Please upload the below to the above application: an Objection from Felpham Parish Council.

Felpham Parish Council discussed the above application at our Planning Committee last evening (14th July) following the deferment of this application at the Arun Development Control Committee meeting of June 26th. As Chair of the Planning Committee of Felpham Parish Council I have been asked to write to you to reaffirm the position of Felpham Parish Council with regards to this application noting that the applicant wishes to have this item addressed at the Development Control Committee on July 29th.

Figure 4.3 Survey Area and Maximum Parking Capacities

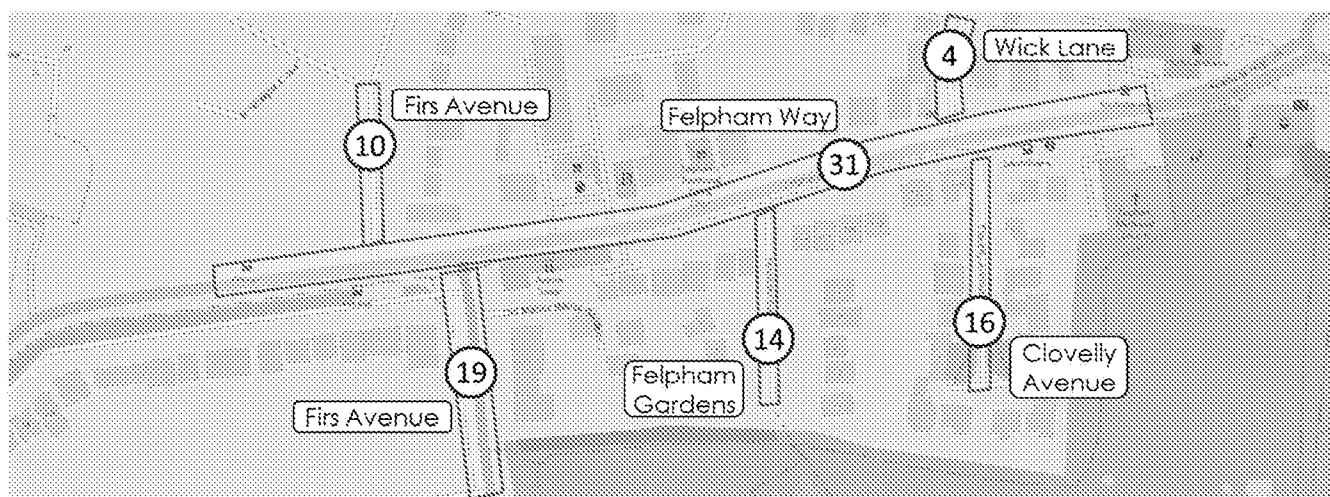
The applicant endeavoured to show via a Lambeth survey that there was sufficient on street parking to allow this development to go ahead with no on site provision for parking. This survey is, in our opinion, fundamentally flawed and has many errors within it. Some of these are as follows, which gives a flavour of the inaccuracy of the document, and I am sure given further scrutiny would elicit further inaccuracies.

1) Felpham Way was called Felpham Road (which is actually by St. Marys Church) and nearly a mile away from the application site;

2) 50 of the spaces detailed in the survey were in Summerley Lane, Firs Avenue, Felpham Gardens, Wick Lane and Clovelly Avenue yet it was claimed that these were within 200m of the development site (as stated by the applicant in their statement to the Development Control Committee dated 23rd June 2020), when most are patently not;

3) The Survey actually called Summerley Lane as Firs Avenue (thus there were two of them!). Firs Avenue is on the north side of Felpham Way whilst Summerley Lane is on the south side;

4) By their own measurements the 30 spaces detailed as being in Felpham Way would be a minimum of 180m in length. These could not be located going west (due to the Petrol station entrance and exit, a pedestrian crossing and a roundabout). They could neither go on the south side (as double yellow lines). So where could they go? On the north side going east there are at least 8 drop kerbs which have to be kept clear. Thus the 180 metres would have to be "stretched" significantly longer (possibly up to Wick Lane - itself a notoriously difficult junction to get out of) and therefore again not within 200m of the development.

The survey can only be construed as poor, inaccurate, misleading and done in haste and without checking. So many errors and inaccuracies does, again in our opinion, make the survey compromised and of not sufficient accuracy or professionalism to offer sufficient mitigation for it to be used instead of the application of the Arun District Council Parking Standards Supplementary Planning Document.
